***MODIFICATION REQUEST:
Hurstville Private Hospital
37 Gloucester Road, Hurstville
(MP 11_0042 MOD 2)***

Modification to the internal layout, changes to the façade, increase in height of the lift shaft and expanded plant area on the rooftop

Secretary's Environmental Assessment Report
Section 75W of the *Environmental Planning and
Assessment Act 1979*

December 2014

TITLE:
SHADOW DIAGRAMS SHEET 2

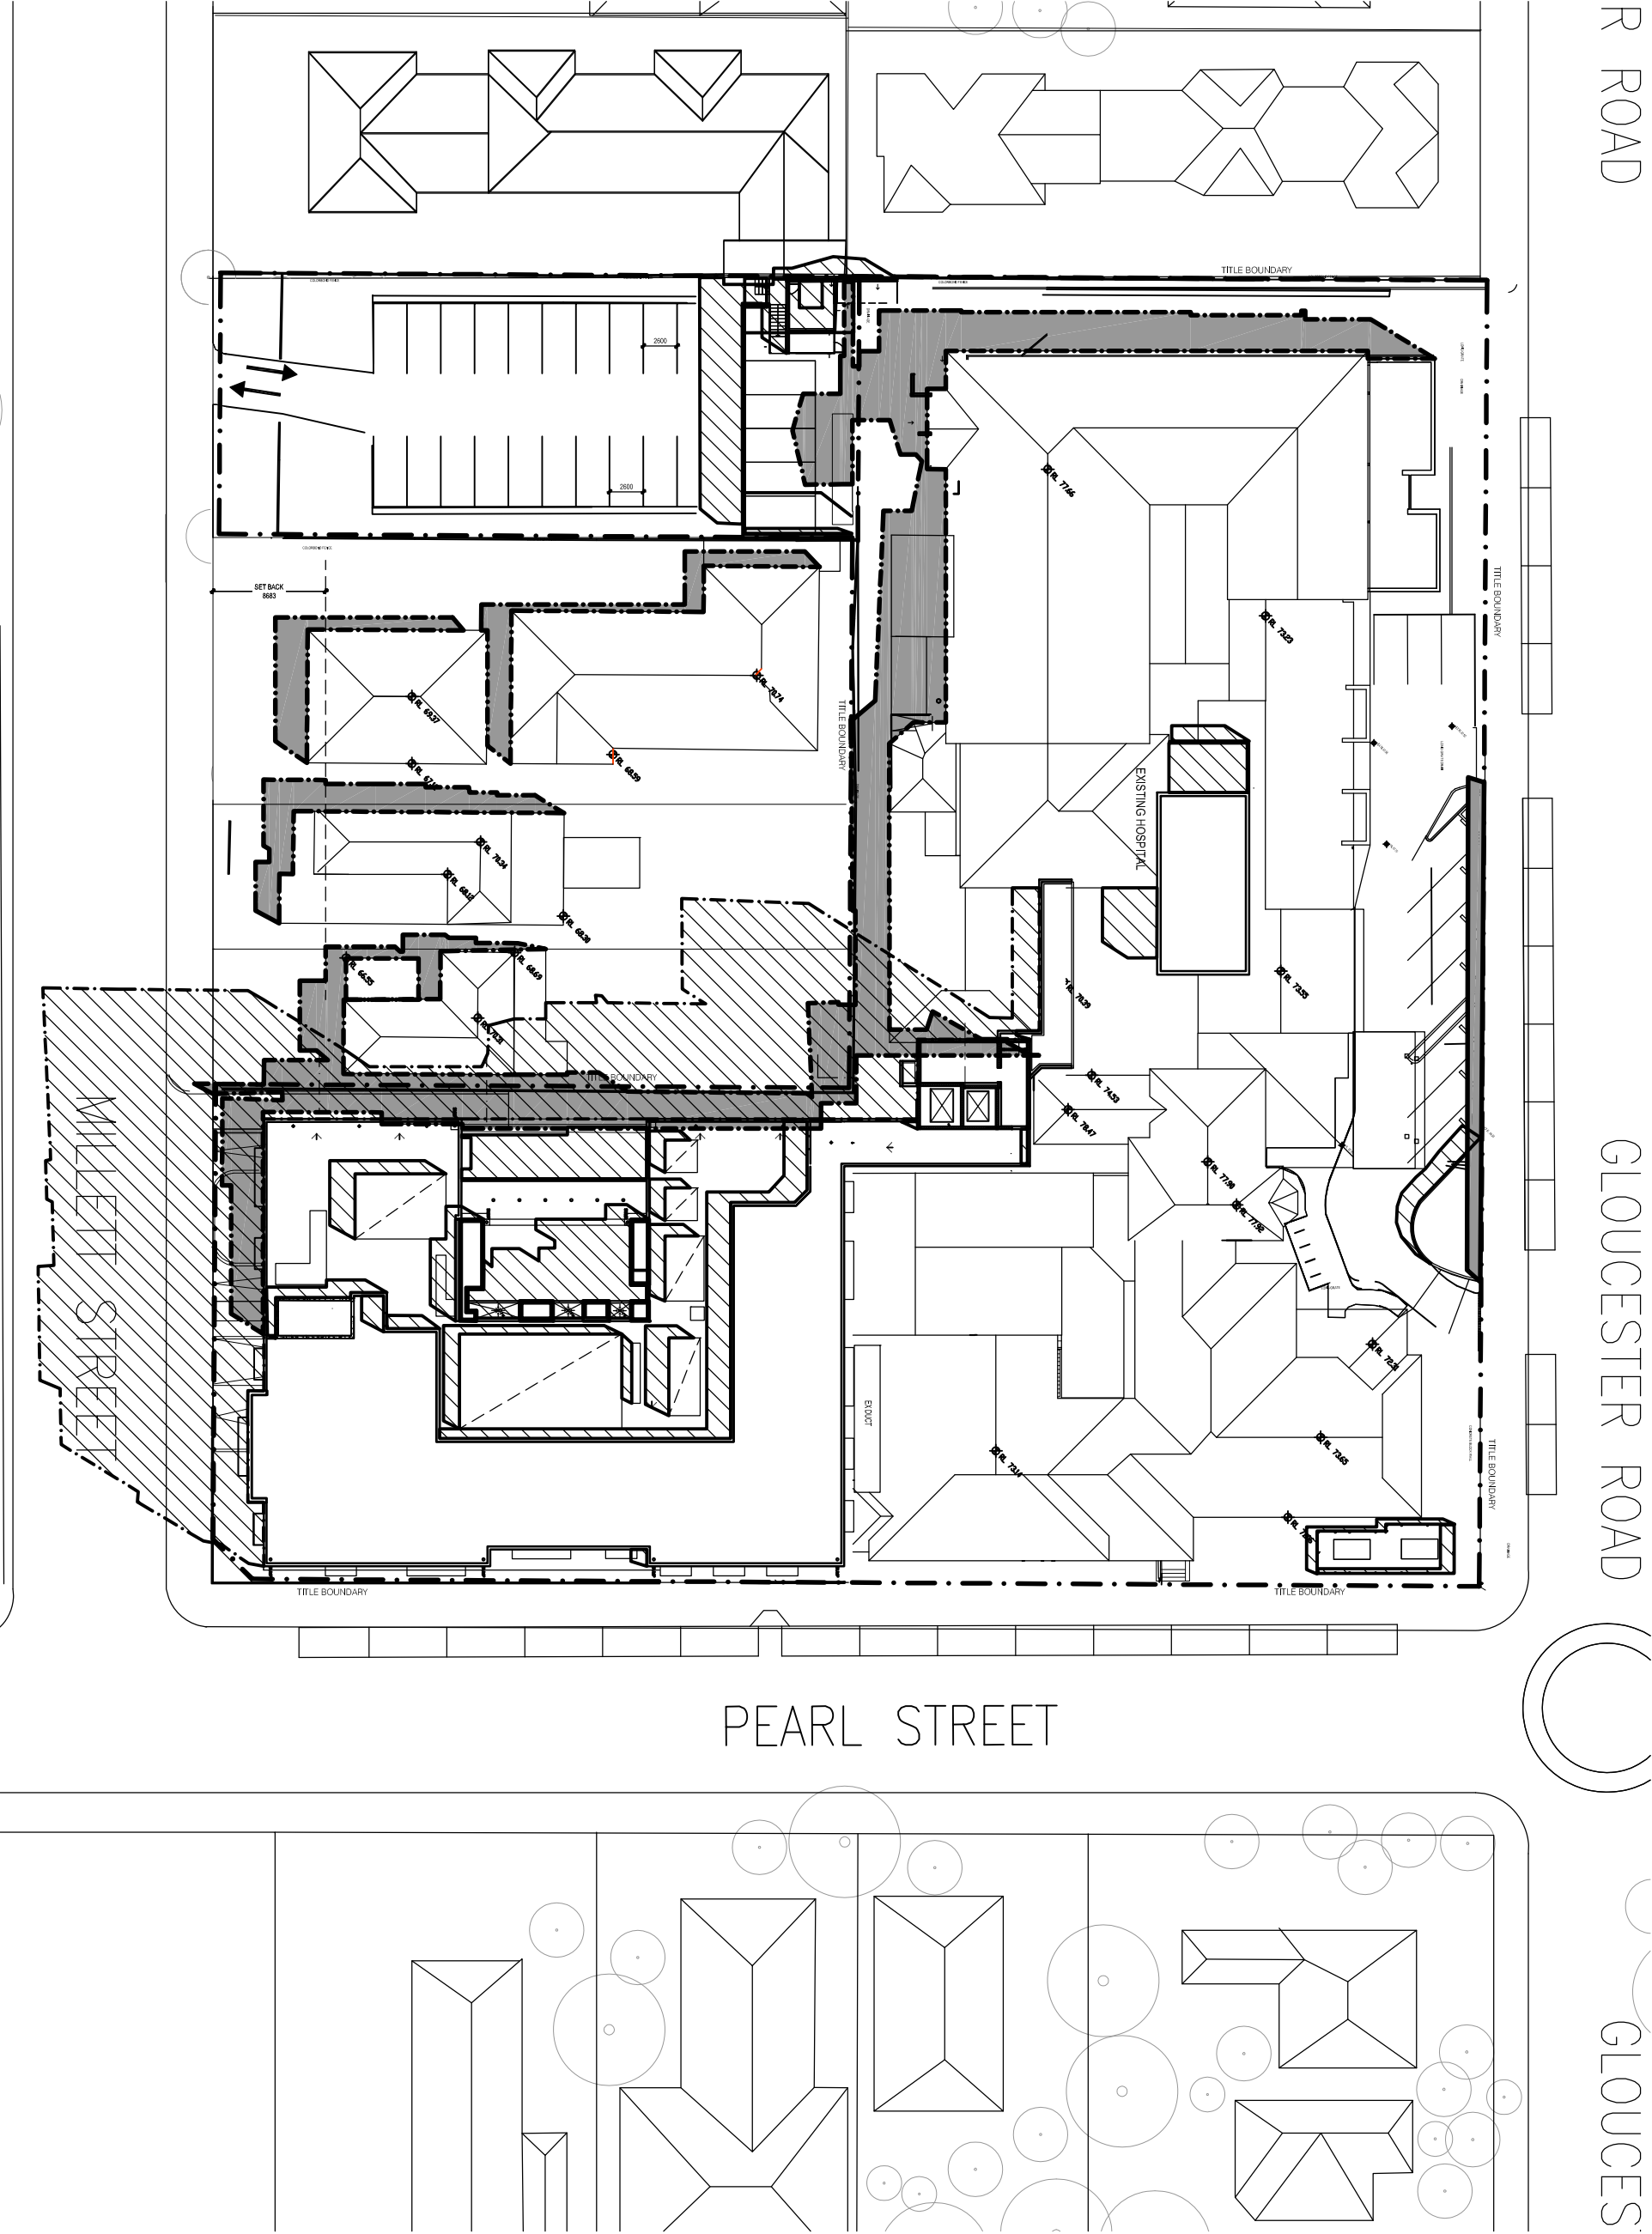
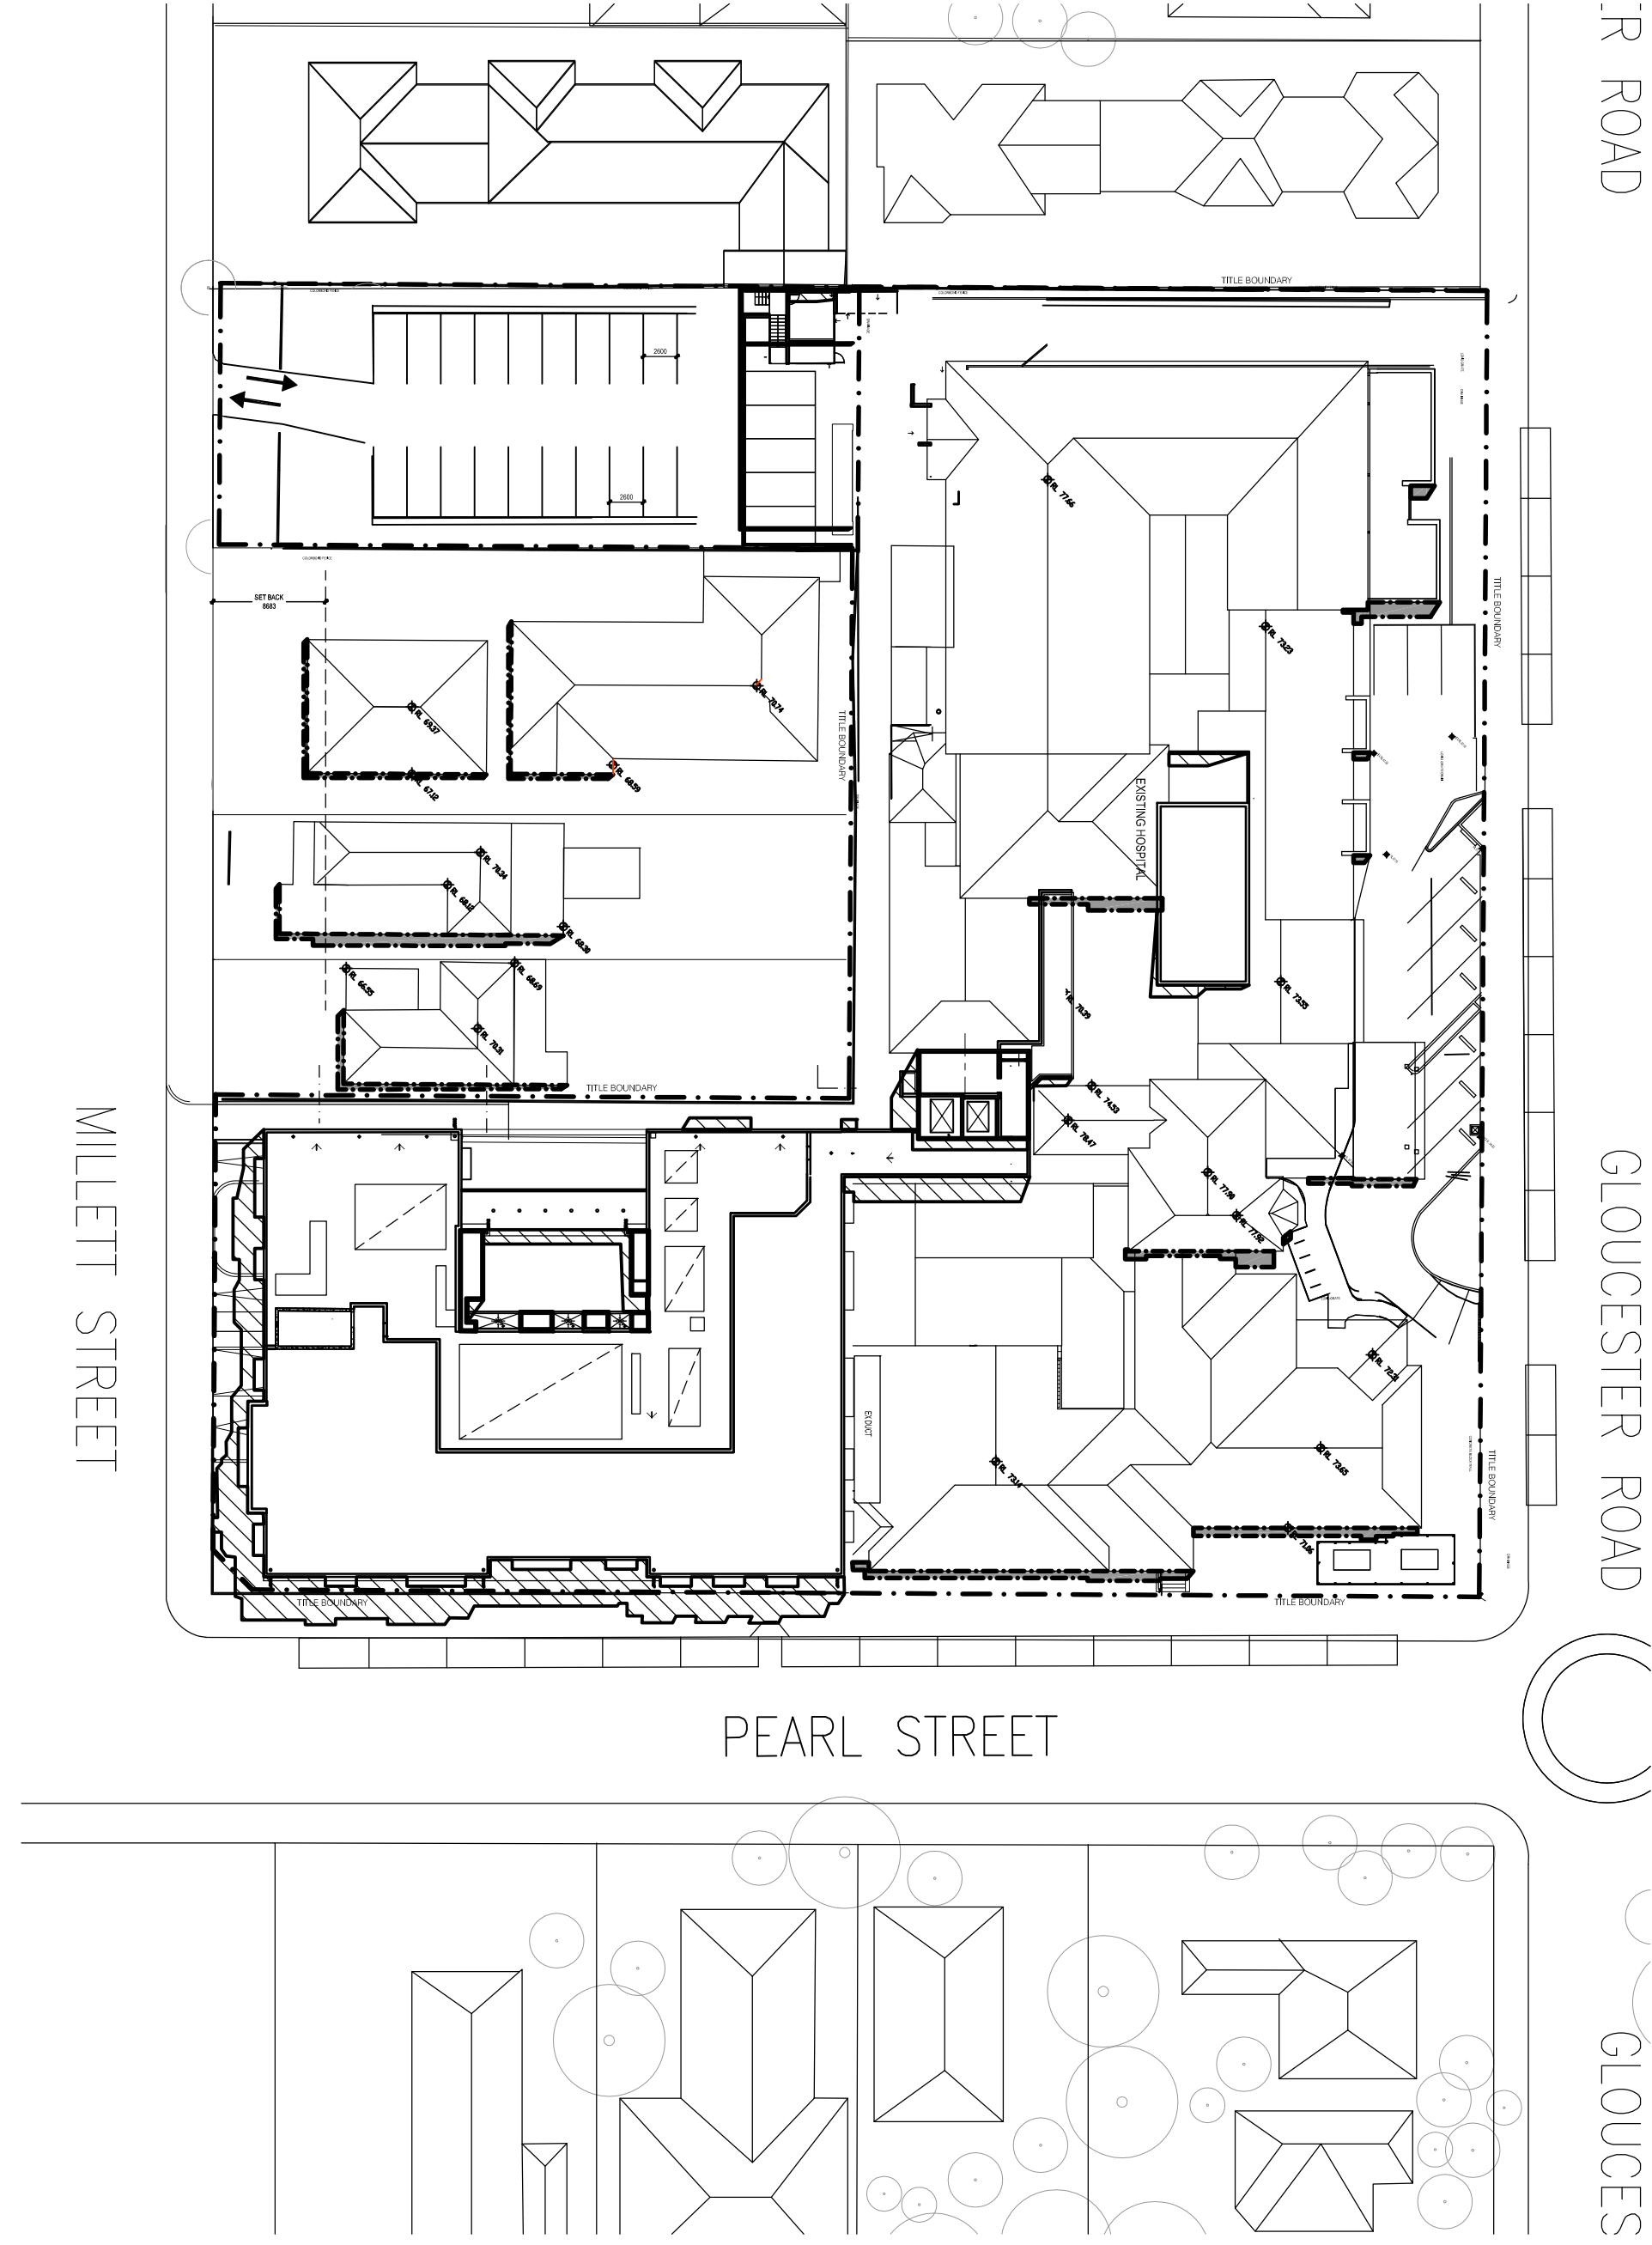
The additional height associated with the lift core also has the potential to adversely impact on the amenity currently enjoyed by the adjoining low scale residential properties directly to the south-west, fronting onto Millett Street. The proposed additional height would be readily visible above the parapet of the main building from these properties. However, the additional height would be offset by the removal of the link-way at the base of the lift core (as a consequence of the link corridor being relocated to the Gloucester Road side of the core), which would introduce a more slender building form (see **Figure 4**). The additional height associated with the lift overrun would also introduce some articulation to the roof line and assist in breaking up the mass of the building when viewed from the rear of the adjacent residential properties. Shadow diagrams submitted with the modification application demonstrate that there will be negligible additional shadow impacts on the rear of residential properties in Millett Street.
